Application Ref:	2025/0756				Ribble Valley Borough Council www.ribblevalley.gov.uk	
Date Inspected:	23/10/2025	Site Notice:	23/10/2025			
Officer:	EP					
DELEGATED ITEM FILE REPORT:					APPROVAL

Development Description:	Proposed single-storey rear extension incorporating first-floor balcony.
Site Address/Location:	4 Meadowlands Clitheroe Lancs BB7 2ND.

7247 - P01A

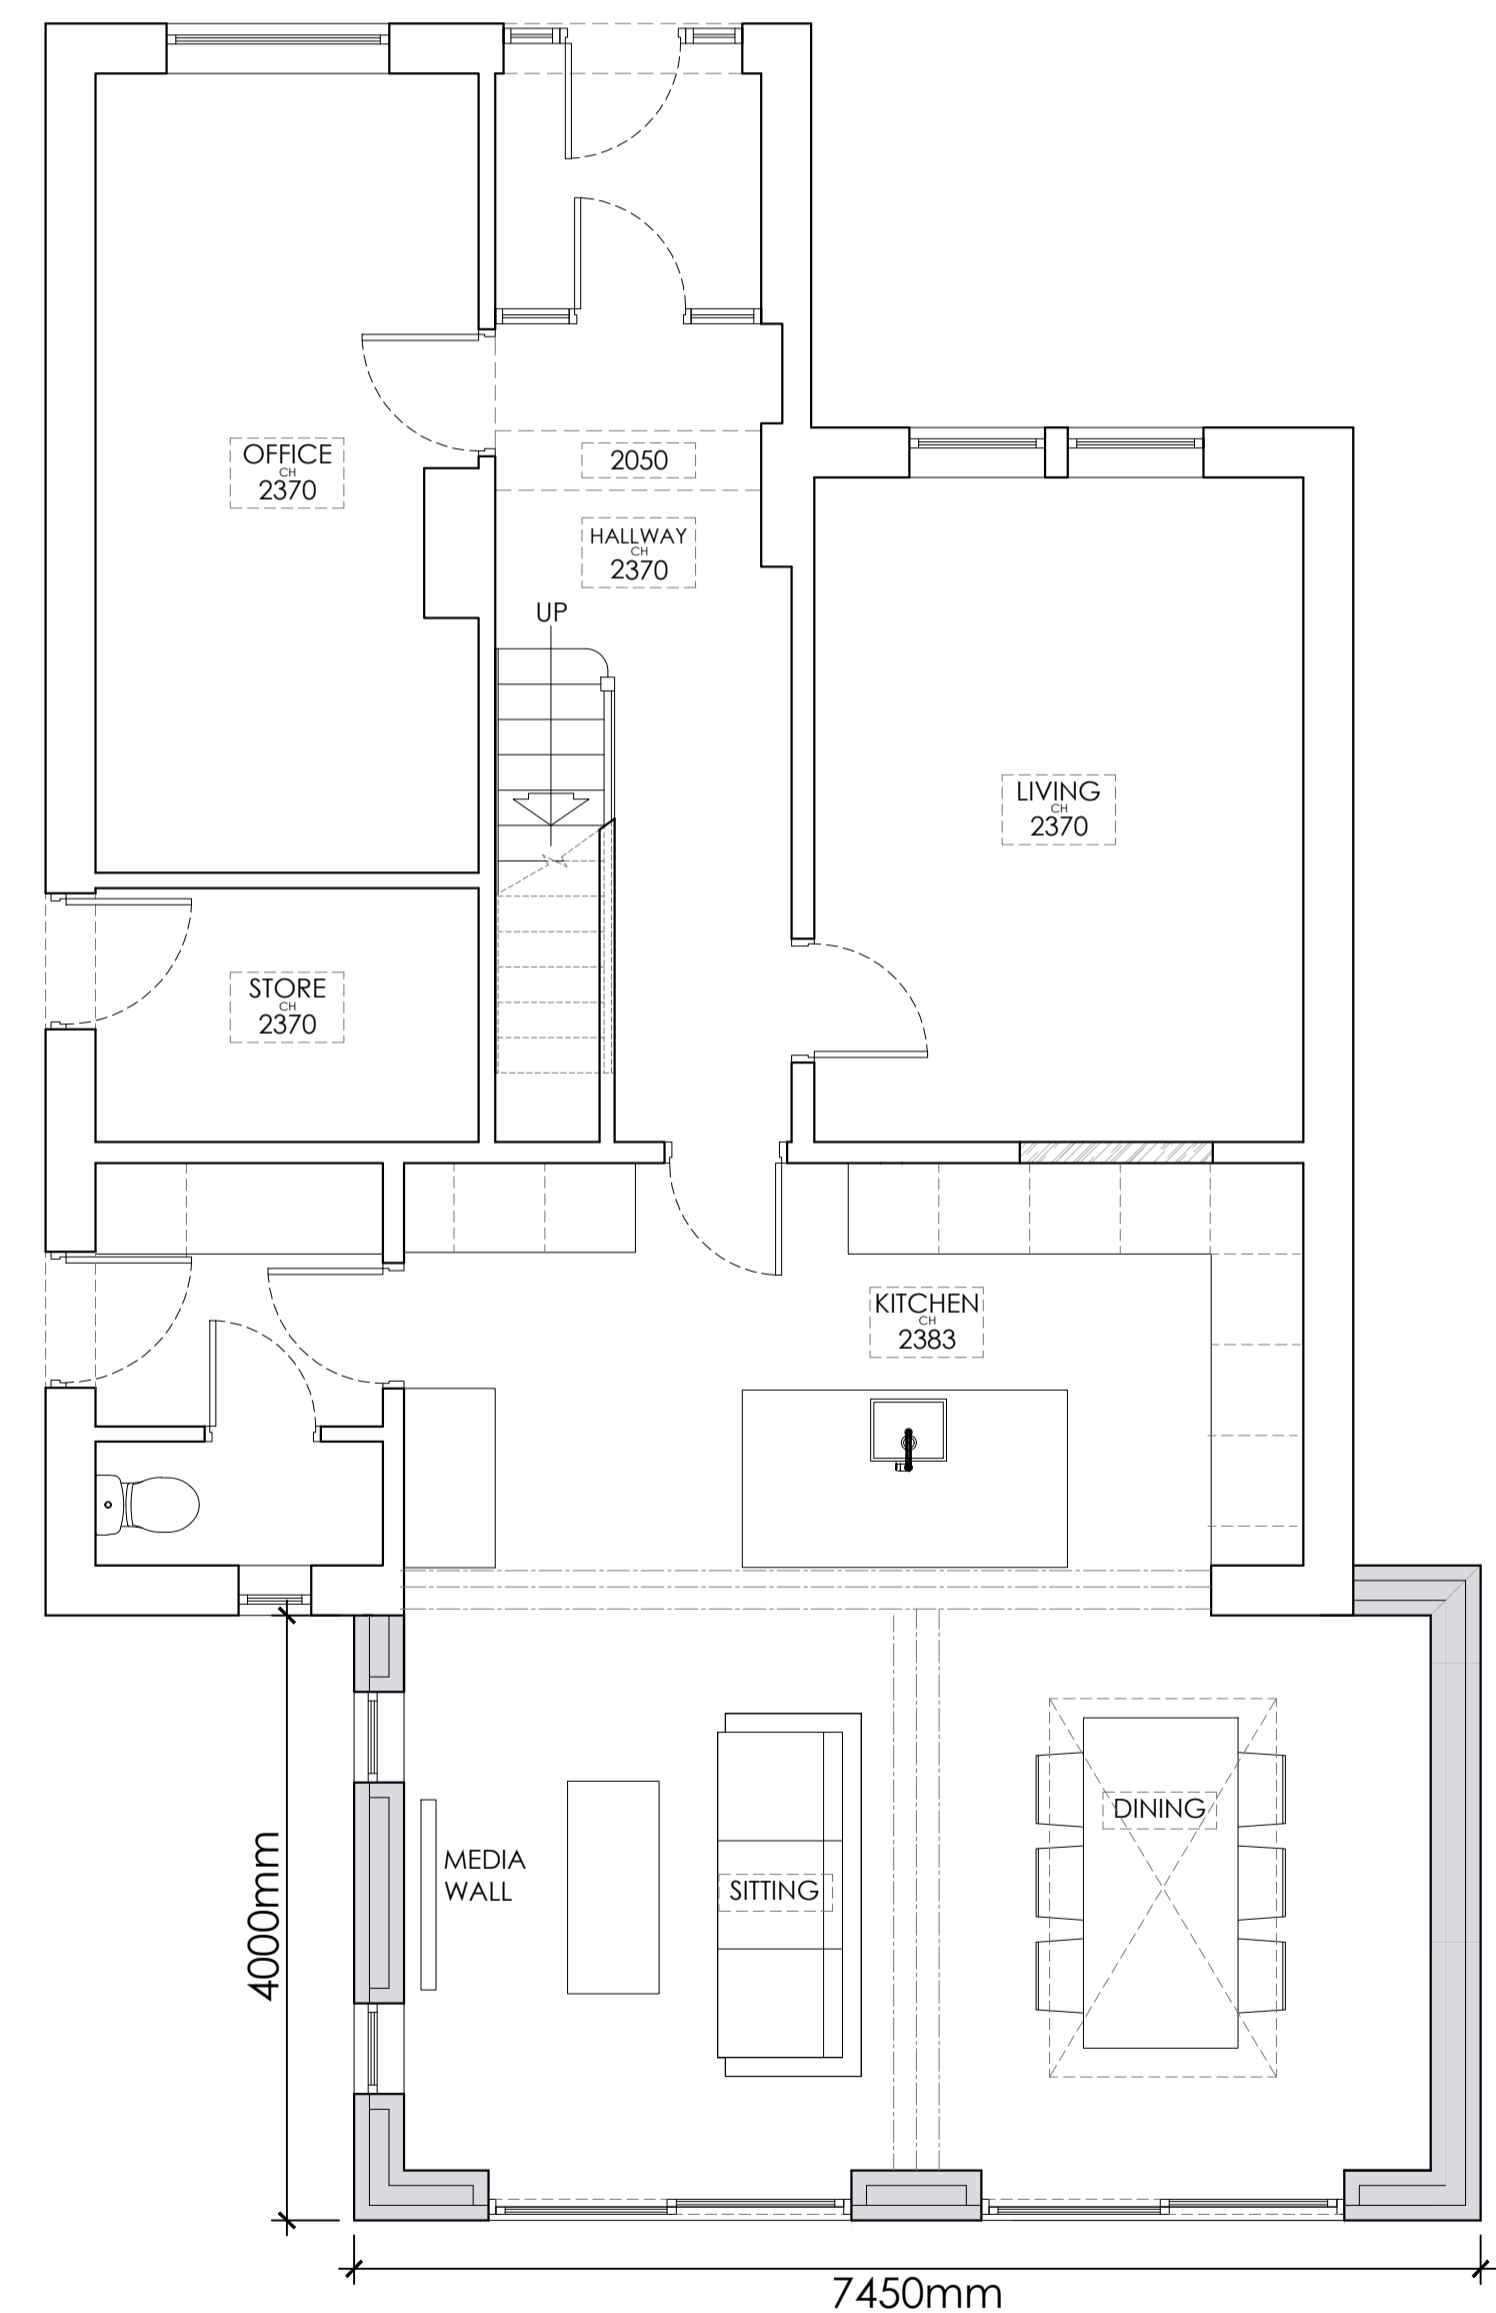
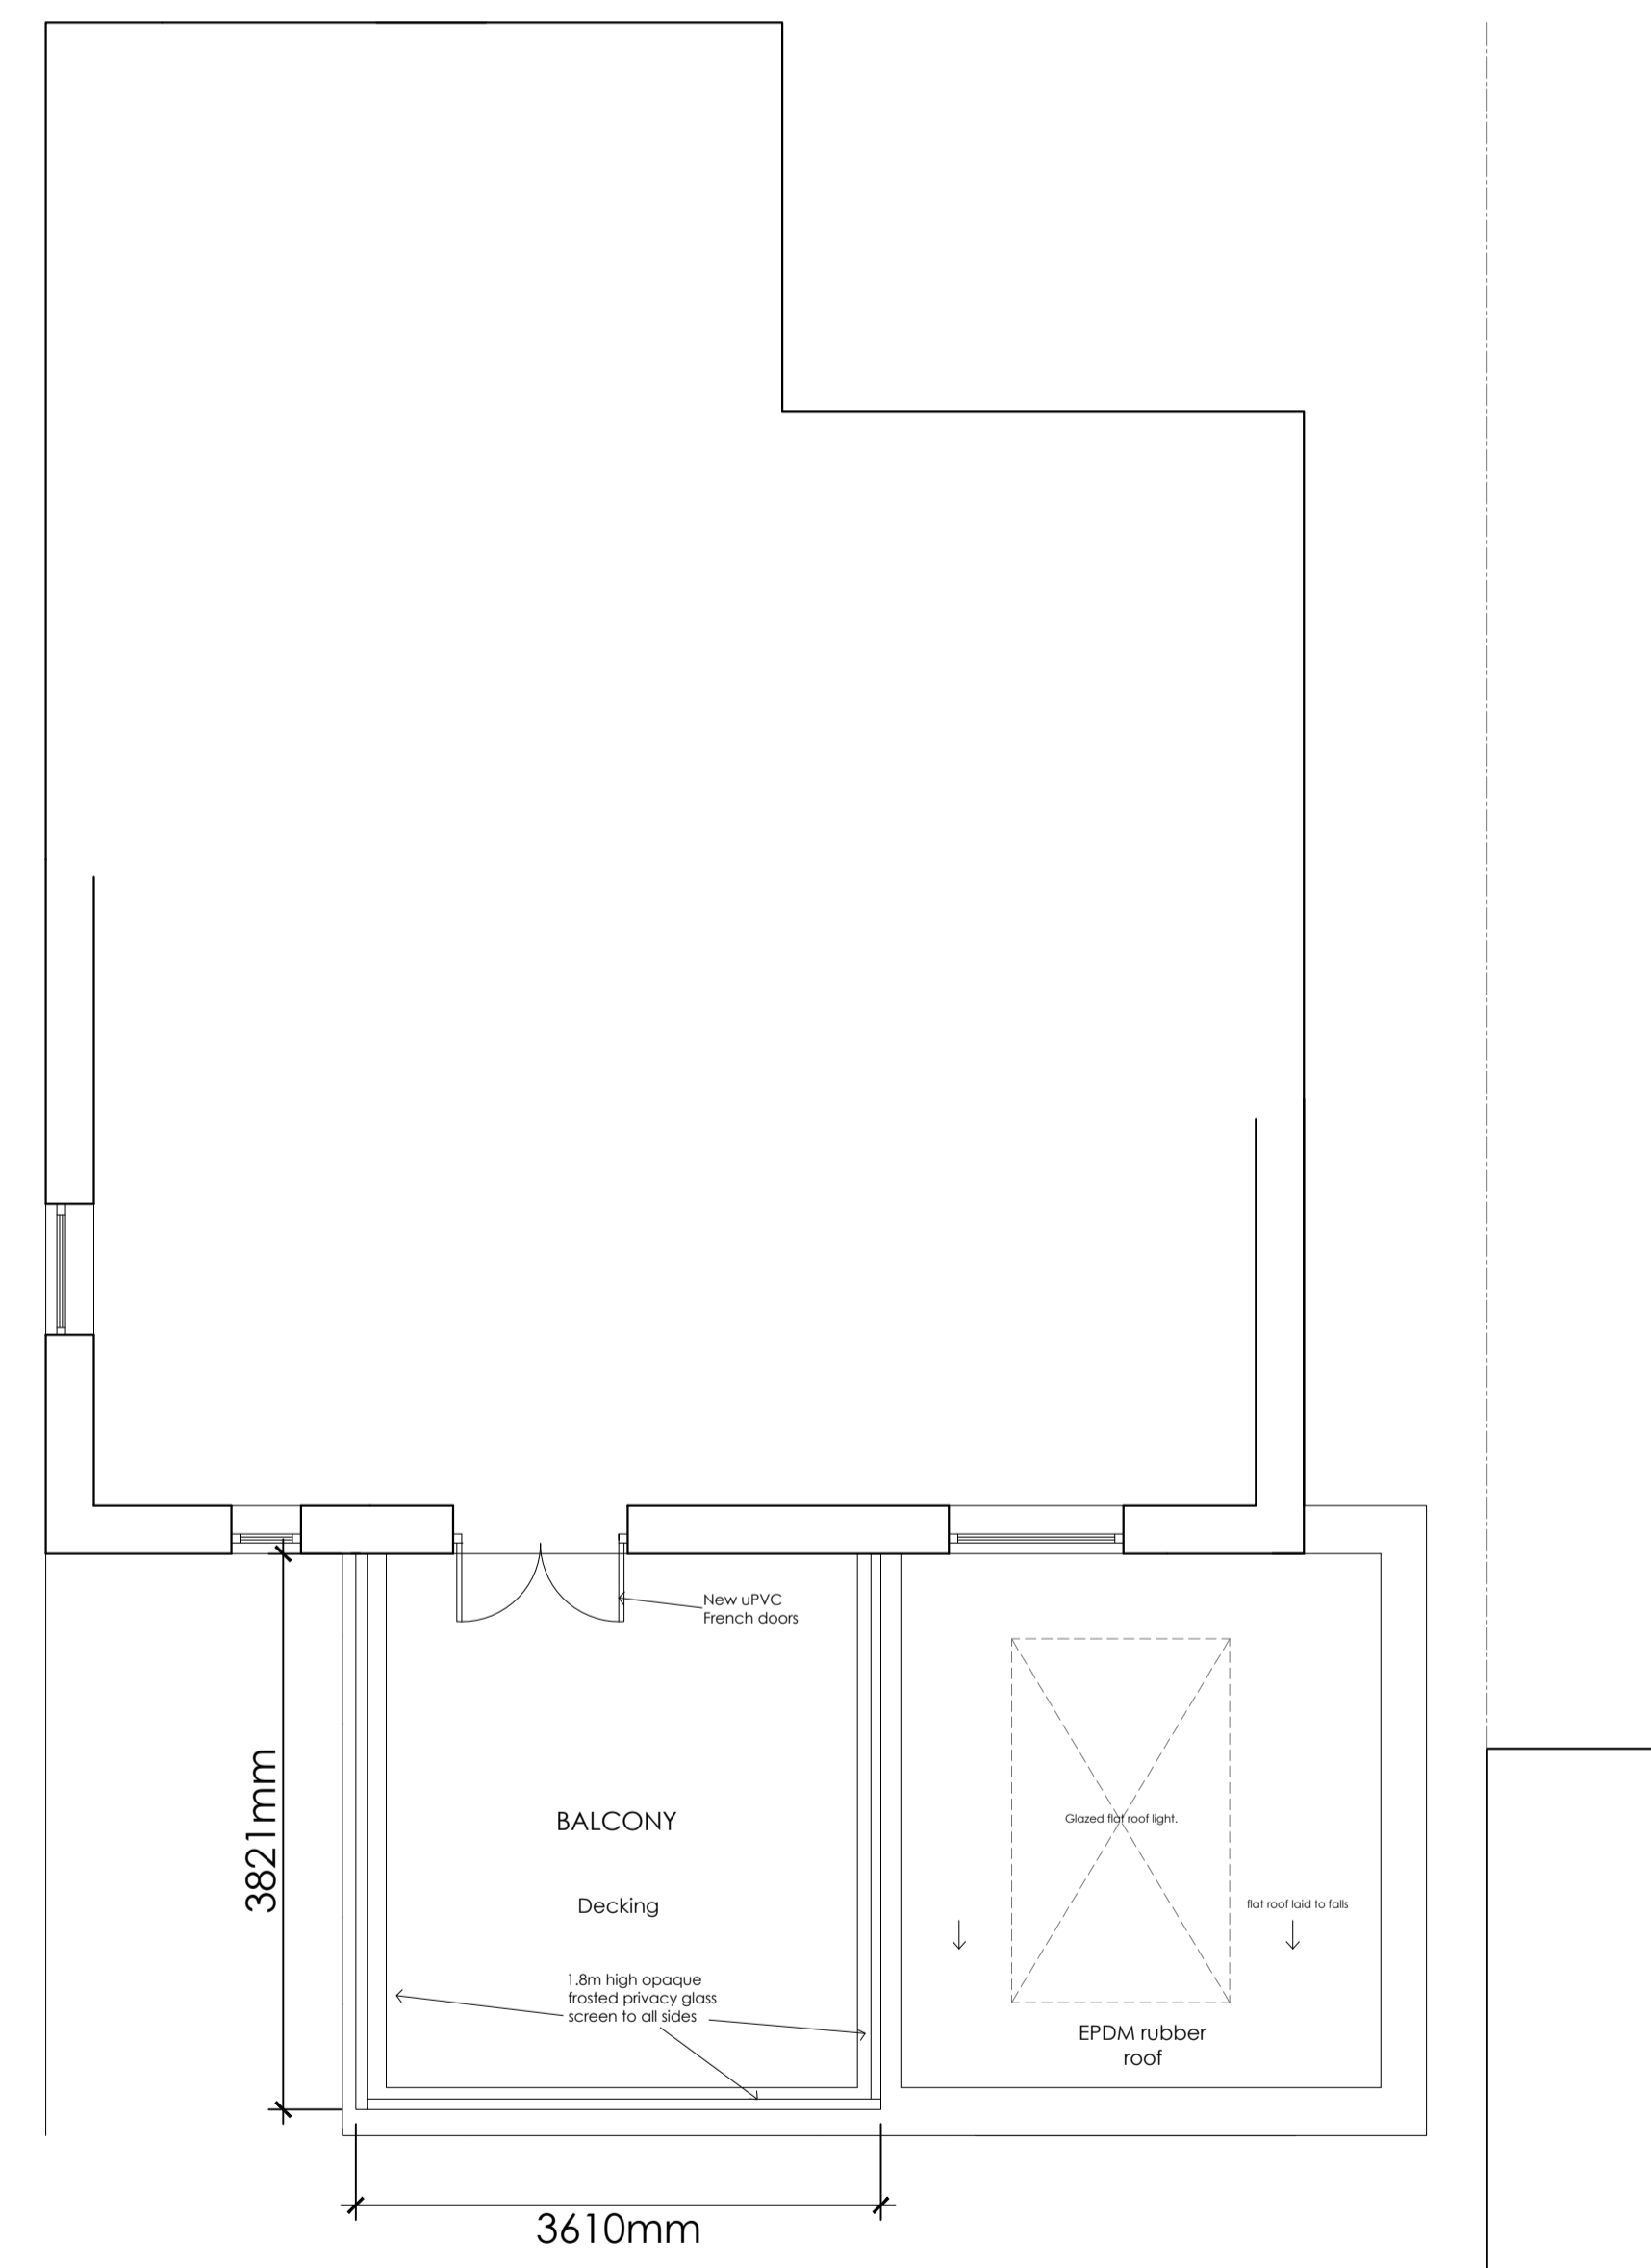
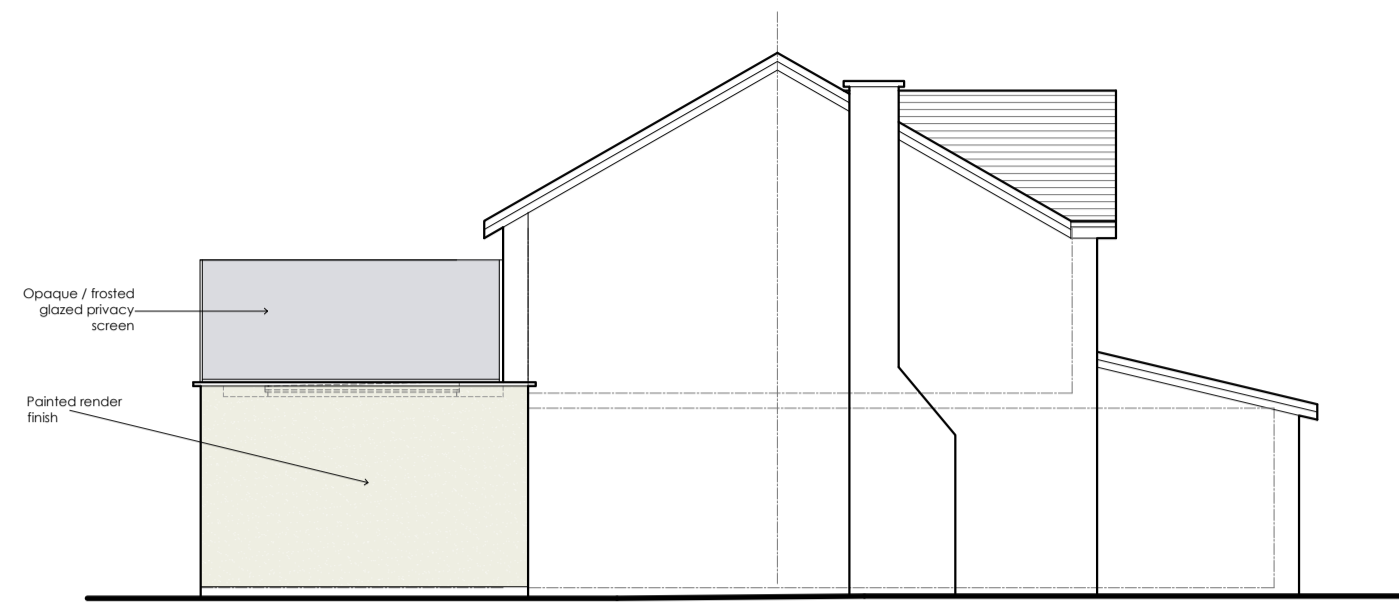
CONSULTATIONS:	Parish/Town Council
Clitheroe Town Council raised no objection but felt the balcony was unnecessarily intrusive and should not be included.

The proposed balcony has the potential to adversely impact neighbouring receptors by virtue of overlooking, as such careful consideration must be given to this part of the proposal.

The property to the Northeast, No.5 meadowlands, fronts the northern side elevation of the application dwelling. There is approximately 18 meters between the principal elevation of the neighbouring dwelling and the edge of the proposed balcony, this distance and the existing boundary treatment paired with the addition of the proposed privacy screen will suitably mitigate any potential adverse impact for this receptor.

Similarly, the neighbouring apartments on Ribble Way to the rear of the site are approximately 20m away from the edge of the proposed balcony. Whilst this is almost a sufficient distance to mitigate overlooking into habitable windows, there is private amenity space between the balcony and neighbouring apartments for which there is potential for an increased perception of overlooking. The addition of the privacy will suitably mitigate any potential for overlooking or the perspective of overlooking.

The properties to the southwest of the proposal along Union St are approximately 40m away from the balcony and therefore there are no direct overlooking concerns from this perspective. There are some parcels of land to the southwest of the application site, which it is believed are residential gardens associated with the properties on Union St. Again, the privacy screen will reasonably mitigate any potential overlooking into this private amenity space.

In order to ensure the privacy screen is reasonably obscure to maintain the privacy of residential receptors, a condition will be placed on the decision to dictate the level of obscurity.

The proposed rear extension will project 4m from the rear elevation of the dwelling, in terms of length this is consent with that that would be allowed under permitted development. As such, given this is also to replace an existing conservatory, there are no concerns over the scale of the proposal. It is sited to the rear of the dwelling and will therefore have no adverse visual impact on the character of the area.

In regard to materials, the extension will be faced in timber cladding to the elevations. Whilst this is not a material commonly found in the locality or on the existing dwelling, given the screened location to the rear, it is not considered this would cause visual harm.

The proposed balcony, given the height, may be partially visible from certain aspects. However, visibility would not be reason for refusal. The glazed structure will integrate sufficiently into the dwelling and not read as an anomalous addition.
